Consultation Response from KC, Conservation & Design

2024/91707 21-23, 25 and 27 Round Ings Road, Outlane, Huddersfield, HD3 3FQ

Discharge of details reserved by Condition 4. (external masonry) & 8. (bi-fold doors) of permission no. 2024/90116 for Listed Building Consent alterations and renovations to existing dwellings 21/23, 25 and 27; erection of single storey extensions to existing dwellings 25 and 27; partial dismantling and re-building of detached barn; conversion and extension of detached and attached barns to form one dwelling; widening/improvements to existing access road, formation of parking and turning areas, together with hard and soft landscaping

Date Responded: 9.8.2024

title General Arrangement as Proposed
number 23038D-02-P06
scale 1:100 or as shown
size A1

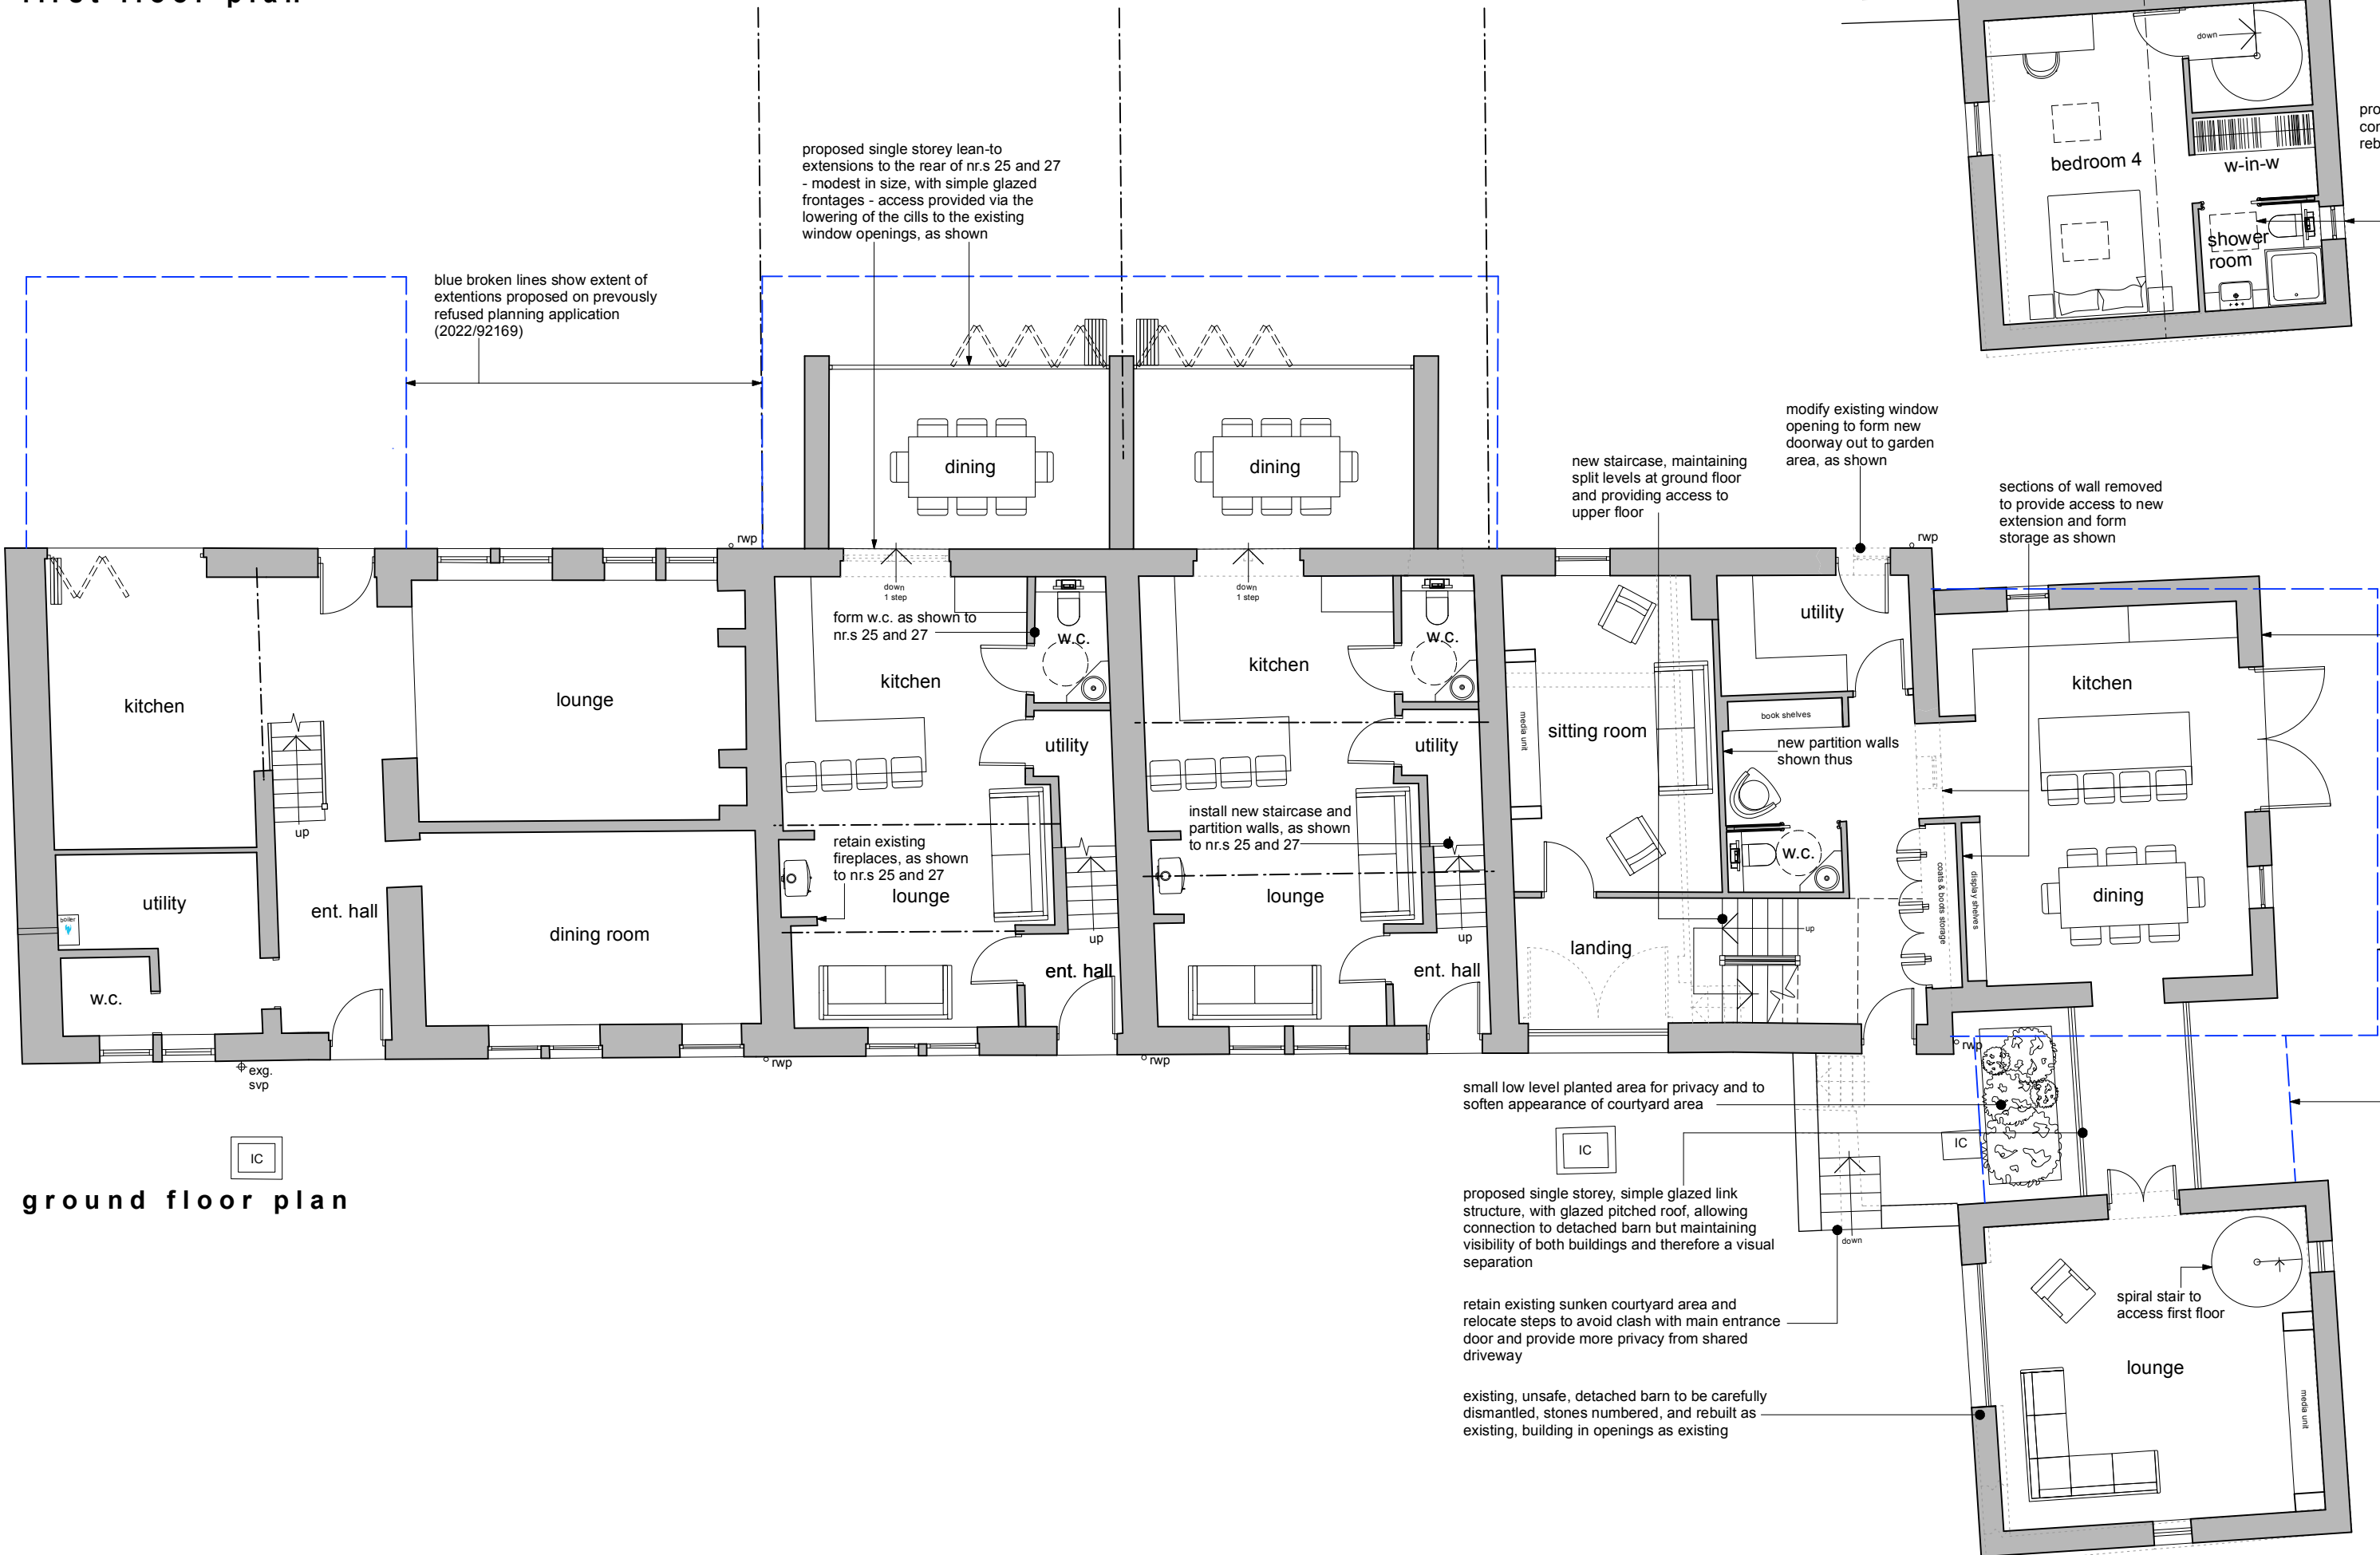
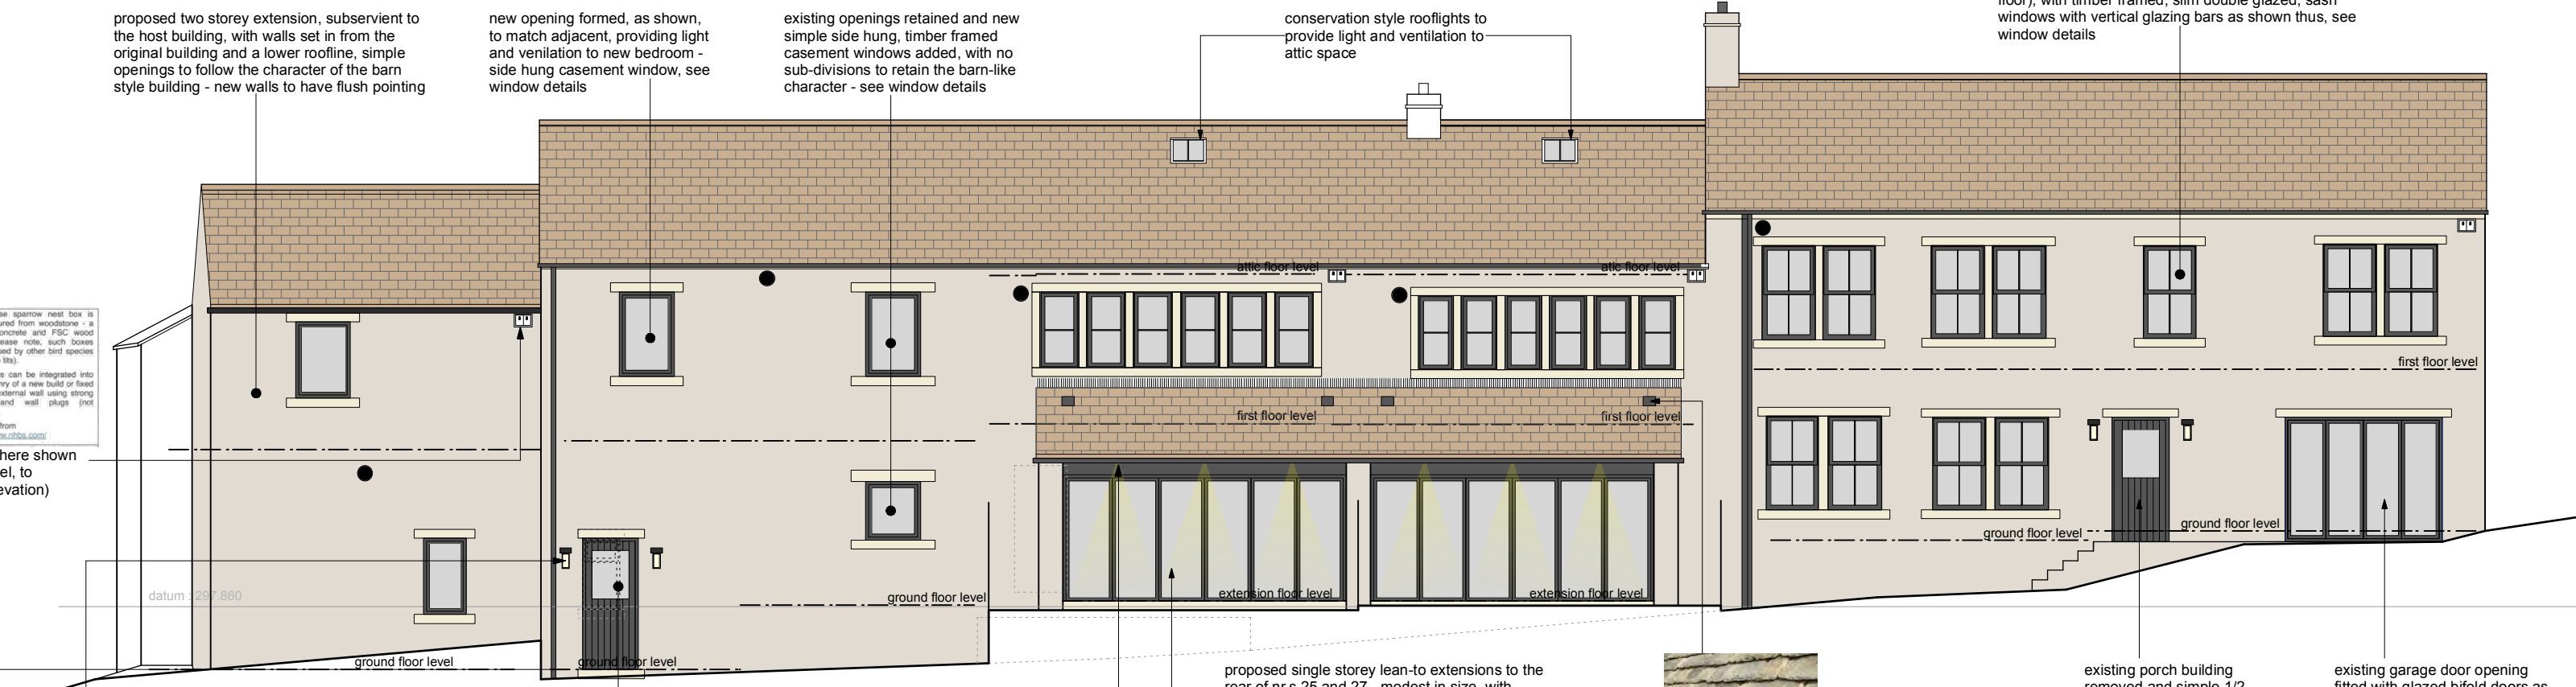
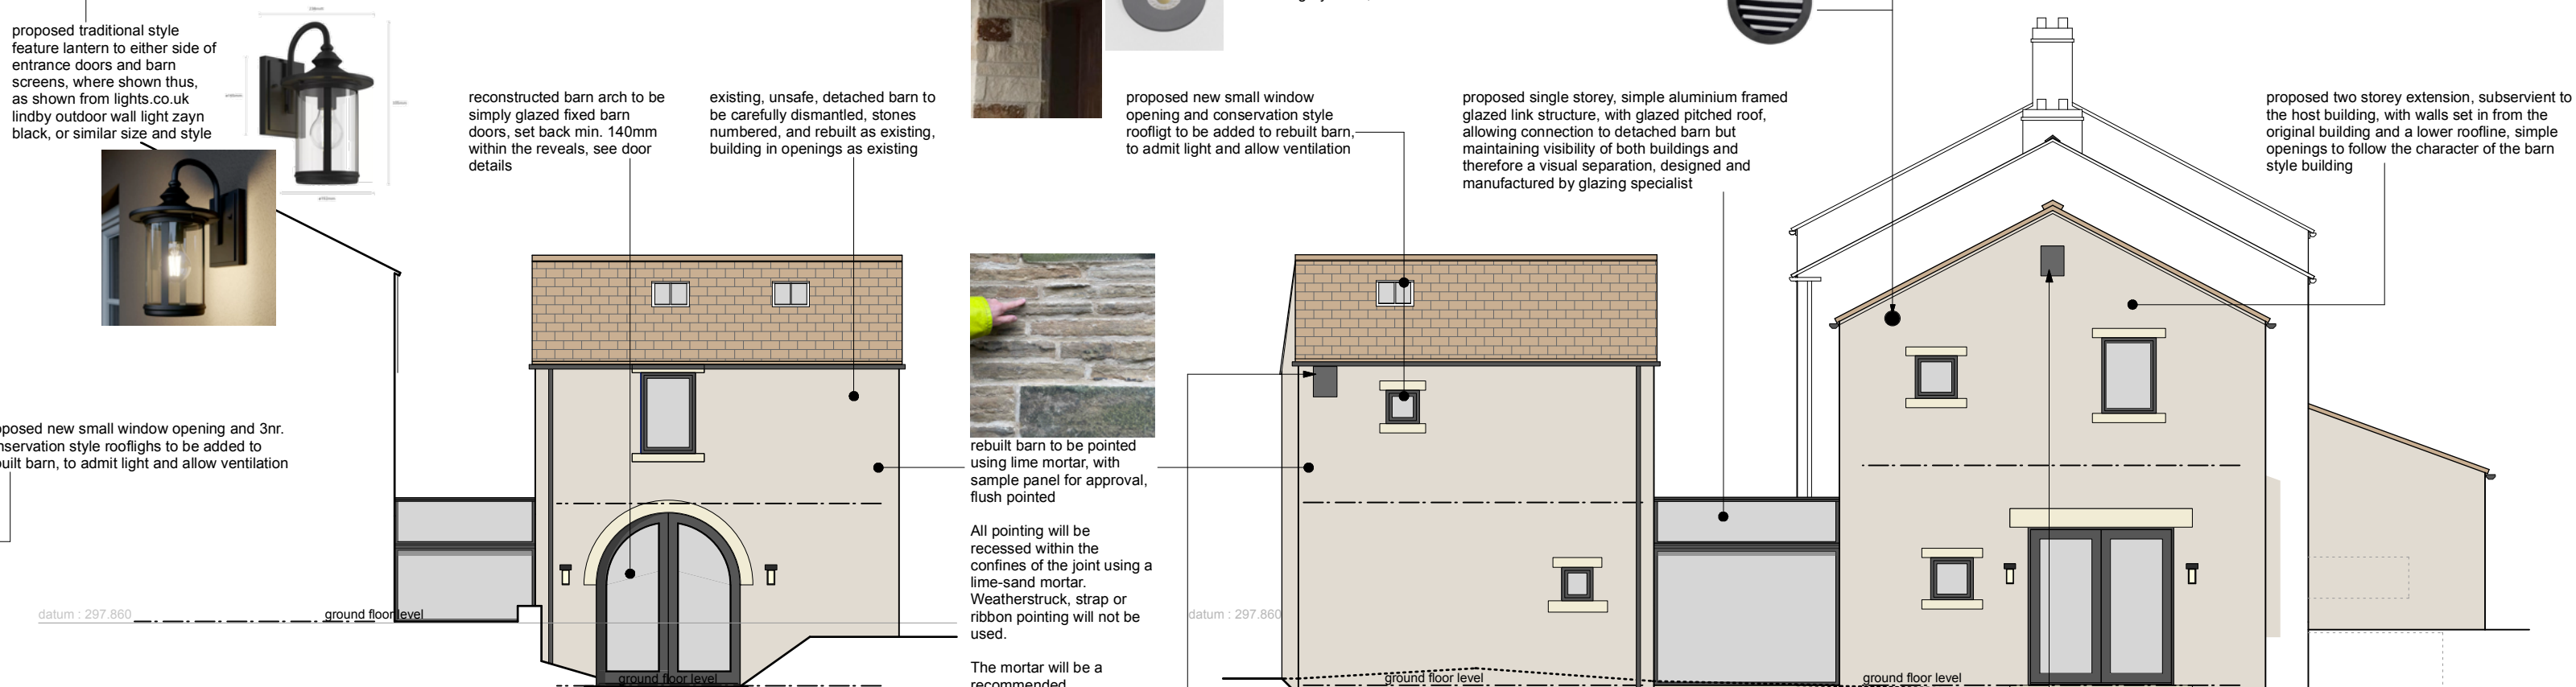
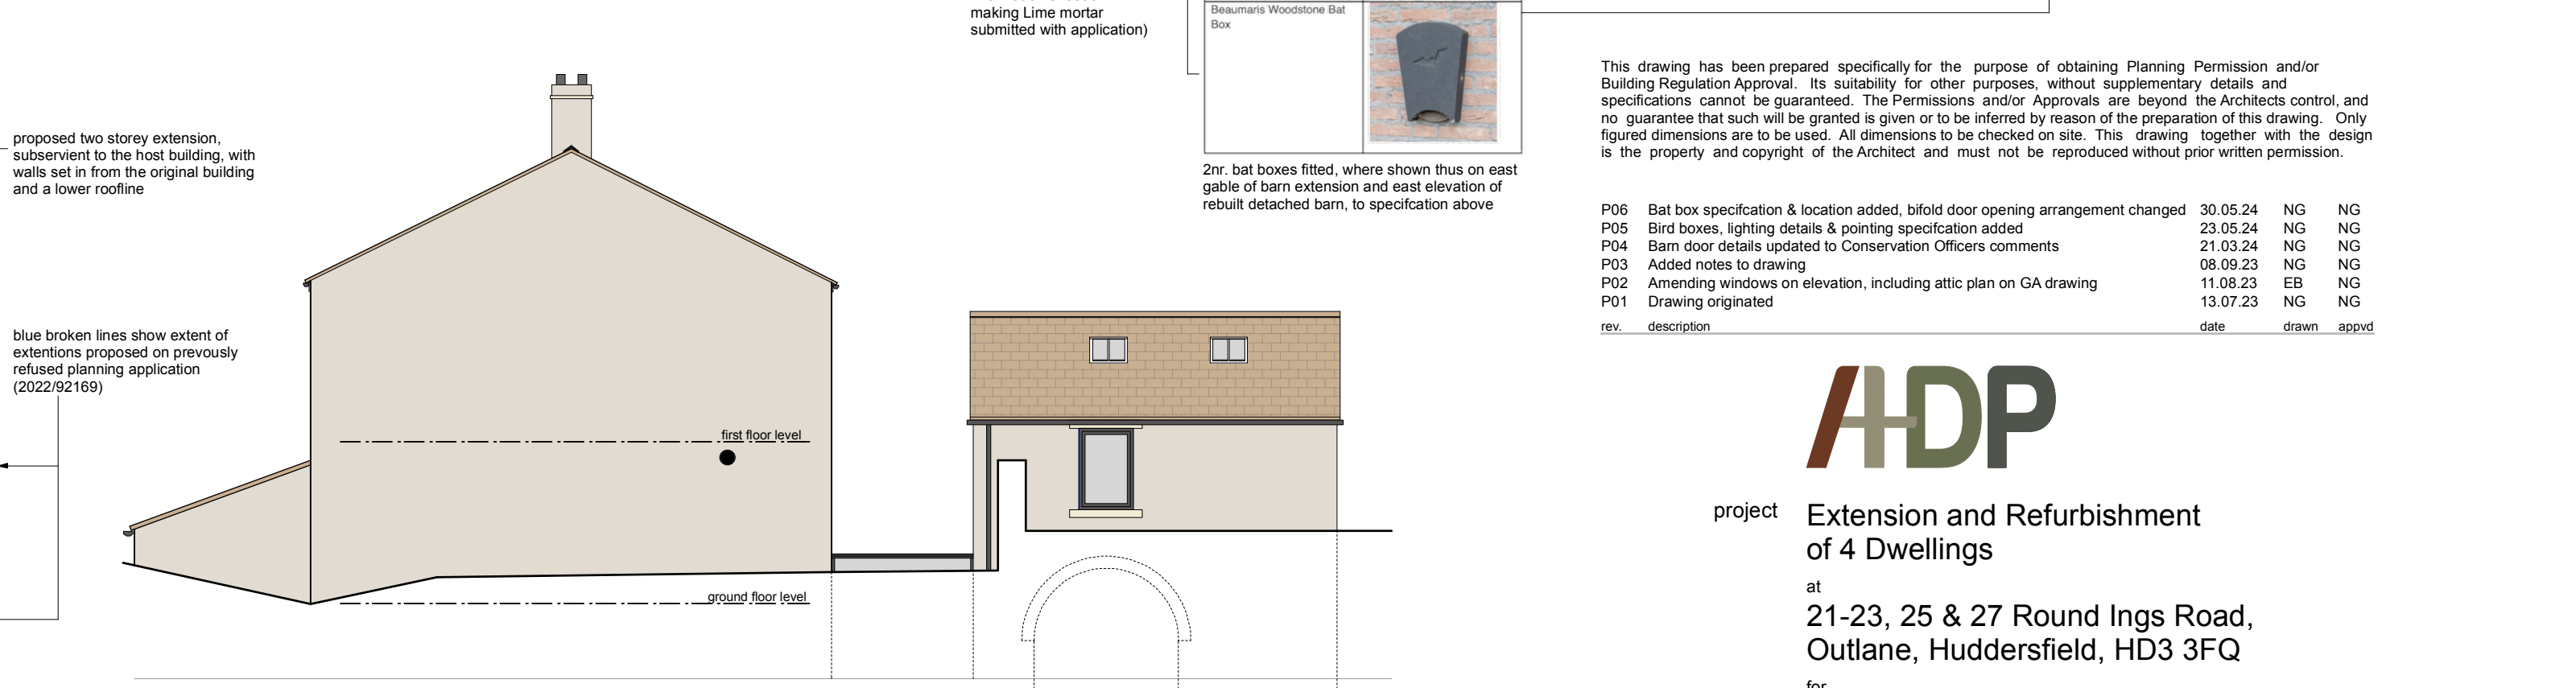
The sample panel photograph submitted on 8th August, the mix and specification submitted as an annotation on drawing 23038D-02-P06, and a mixing method, have been submitted. These are acceptable to discharge this condition.
